July 15, 2016

### RE: Mitchell Short Plat (SP-16-00001)

Kittitas County Community Development Services has determined that the Mitchell Short Plat (SP-16-00001) is compliant with the Comprehensive Plan and Kittitas County Code (KCC) and hereby grants preliminary approval.

**MITCHELL SHORT PLAT
PART OF SECTION 31, T. 20 N., R. 17 E., W.M.
KITITIAS COUNTY, WASHINGTON**

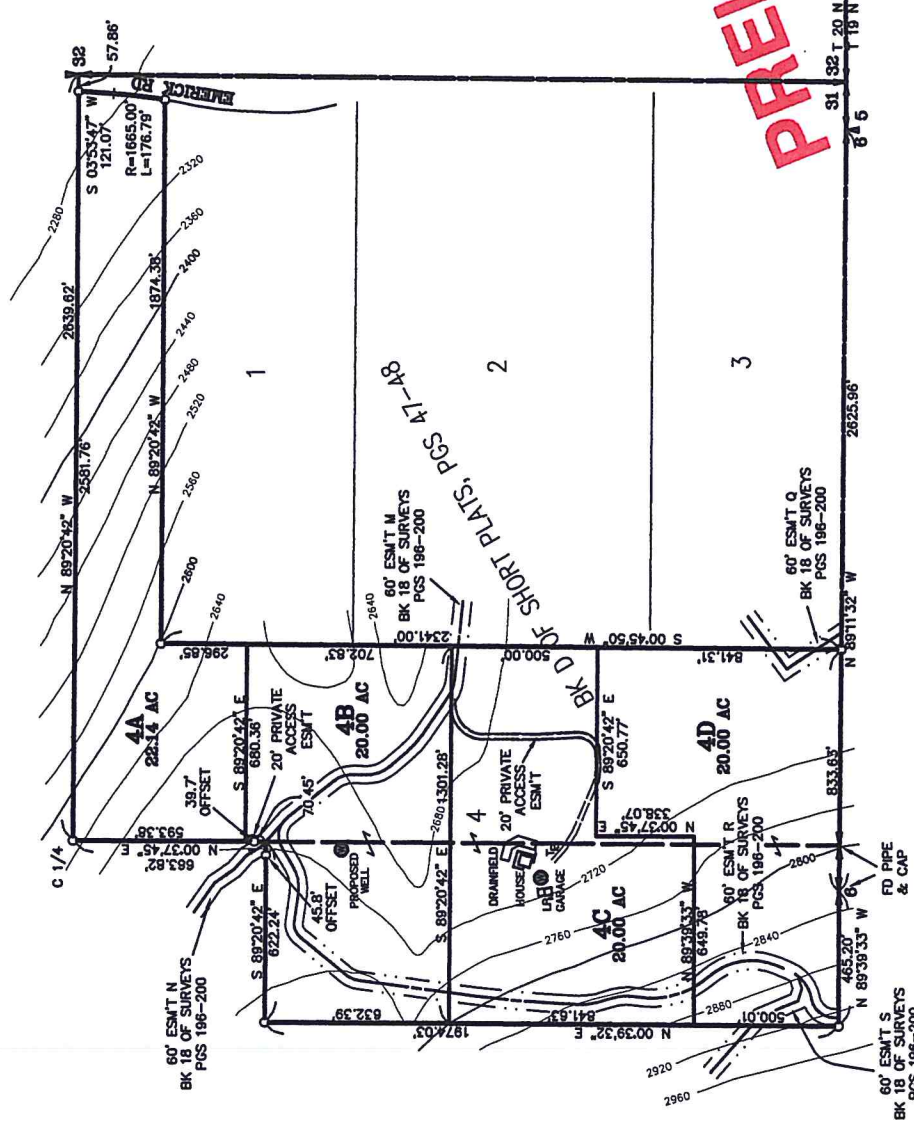
1. Both sheets of the final mylars shall reflect short plat number SP-16-00001 and an accurate legal description shall be shown on the face of the final plat. Engineers and Surveyors need to be cognizant of all of the requirements related to Short Plats (KCC16.32), Final Plats (KCC 16.20), and Survey Data and Dedications (KCC 16.24). The final plat must be submitted in full conformance with these chapters of Kittitas County Code; **non-compliant mylars will be rejected and returned to the applicant.**

7. A potential wetland exists on lot 4D of the Mitchell Short Plat **which shall be depicted on the face of the final plat**. Any future development, construction, or improvements which are proposed to occur within 200 feet of said wetland will require a wetland assessment by a certified wetland biologist to determine whether a wetland exists, if so what type it is, and any appropriate and buffers or mitigation measures.
8. The Kittitas County GIS shows a Type 9 stream traversing lot 4B **which shall be depicted on the face of the final plat**. Any future development, construction, or improvements which are proposed to occur within 15 feet of said stream will require a riparian assessment to determine whether a stream exists, if so the type of stream, and any appropriate buffers or mitigation measures.
